TWEED VALLEY HOSPITAL NSW

ARCHITECTURAL AND URBAN DESIGN RESPONSE TO
EIS AND SSD STAGE 1 APPLICATION SUBMISSIONS

24 JANUARY 2019

AR-SKE-10-007

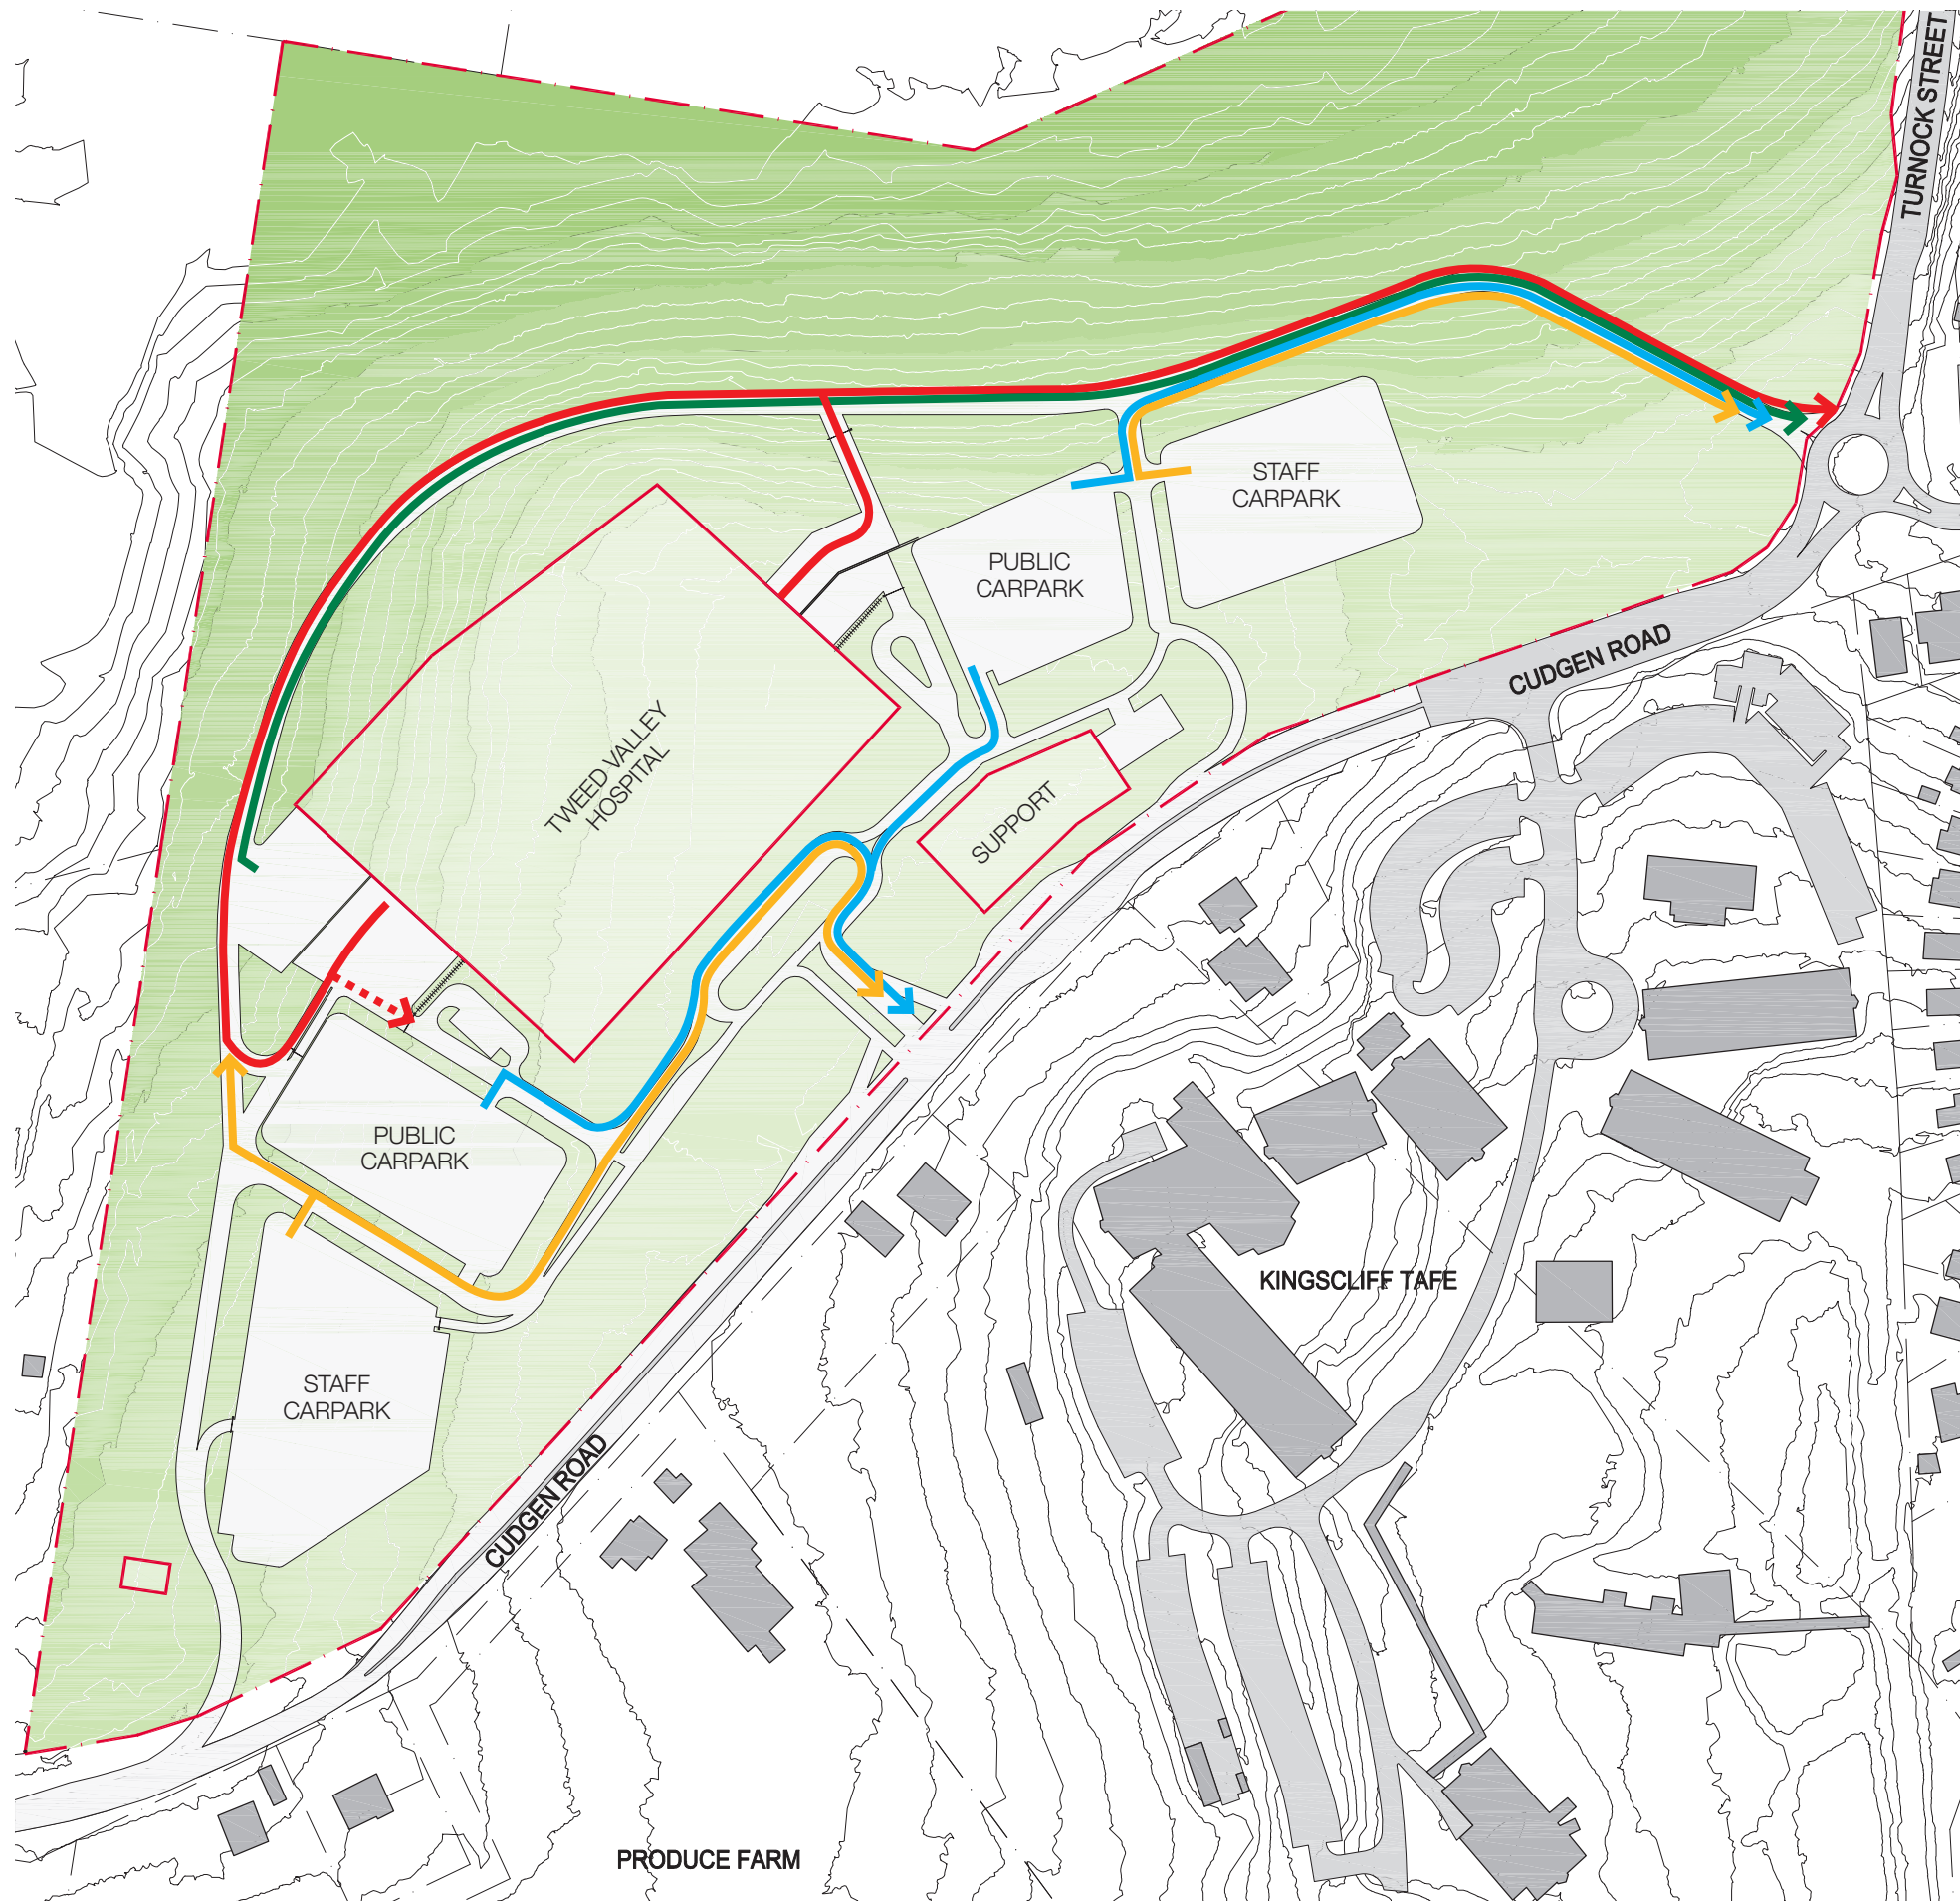
- **a coherent and connected street network that creates a framework for future development**
- **priority given to pedestrian amenity**
- **accommodates multiple modes including pedestrian, bicycle and public transport movements**

The street network is designed to be functional and coherent based the following framework (refer to drawing AR-SKE-10-007 and 008):

- Separation of service and ambulance traffic flows to the north service road using dedicated site entrances A and D.

- Public traffic flows utilise the main entry (supported by intuitive wayfinding strategies) to the main hospital street that runs east-west along the site.
- A single decision point at the main hospital entrance to direct public flows either to the west, for Emergency visitors, or to the east for ambulatory and day patients.
- The main public hospital street can be extended east to accommodate a future connected campus structure.

AR-SKE-10-007

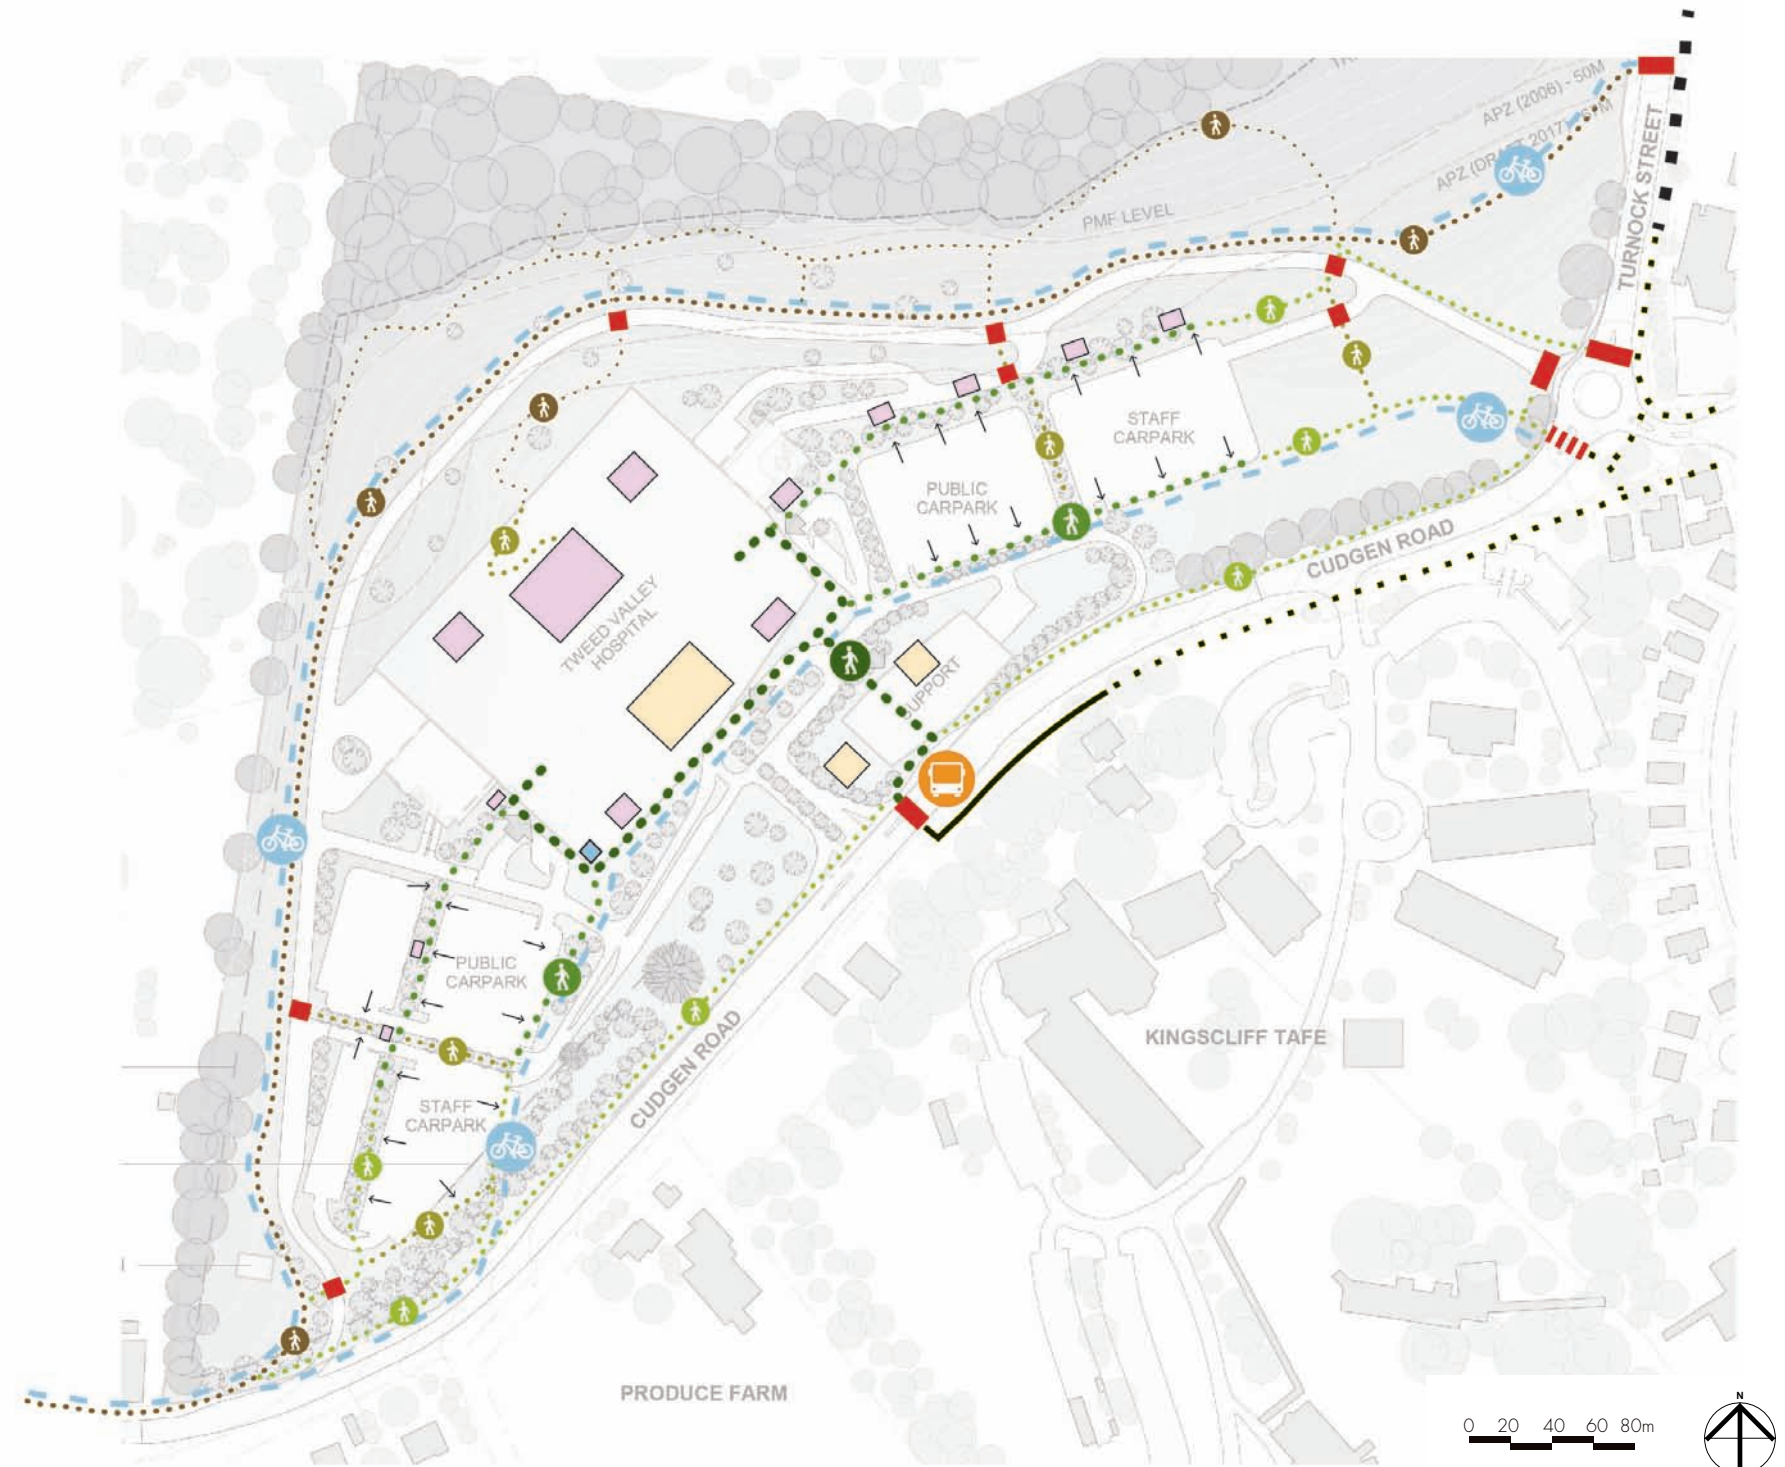
The EIS notes two new bus stops will be provided on Cudgen Road, to the east of the primary signalized intersection. The Master Plan (Drawing No: AR-SKE-10-006) indicates the location of these bus stops. As the proposal seeks approval for the concept plan and Stage 1 works, detailed design of the bus stops have not been provided at this stage, however, should be provided in subsequent stages. Pedestrian access between the hospital and the proposed bus stop within the indented bay on Cudgen Road will need to be provided in accordance with the relevant disability access standards and guidelines.

Detailed design of the bus stop and a site plan indicating the location of the bus stop and the lay-up zone should be provided in future stages. These designs should include consideration of distance and grade requirements to comply with disability access standards/guidelines and be carried out in consultation with TfNSW and the local bus operator to ensure operational safety, accessibility and feasibility.

Noted. The design of the proposed new bus stop, kerbs and walkways are to be developed in accordance with the relevant disability access standards, guidelines and good practice in consultation with the TfNSW. Design consideration will be given to the travel distance from bus stop to the hospital front door, the route of which will include the provision of seating and shelter. The design currently reflects feedback from the local bus operator, however the opportunity to integrate bus routes on the campus would be further investigated in the Stage 2 SSD application.

BUILDING SECTION A
SCALE 1:1000

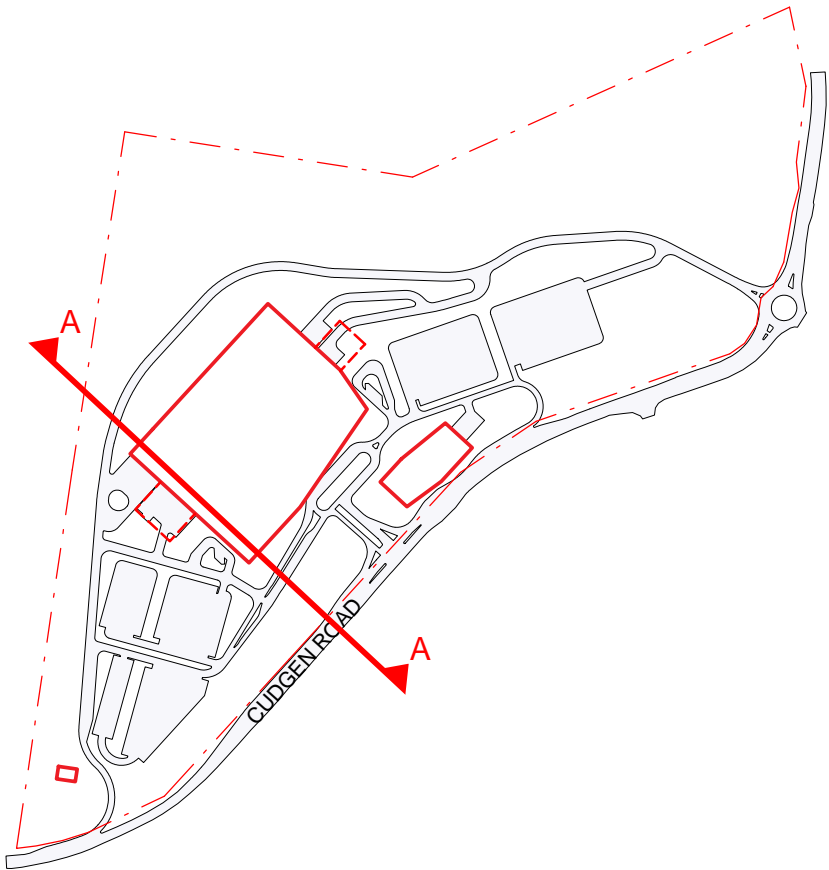
2.2.1 1. Further consideration of the visibility and urban impact of the hospital precinct at both local and regional level

In response to feedback the Maximum Planning Envelope has been modified to further reduce the visually perceivable bulk associated with the upper levels, refer AR-SKE-50-501. The Maximum Planning Envelope is further articulated as grouped floor levels of diminishing density, illustrated in drawing AR-SKE-50-101, 201, 301 and 401 appended. This will ensure the resulting hospital form reduces with height, an example of which is illustrated in Building Section A drawing AR-SKE-51-003 which reflects a work in progress block form.
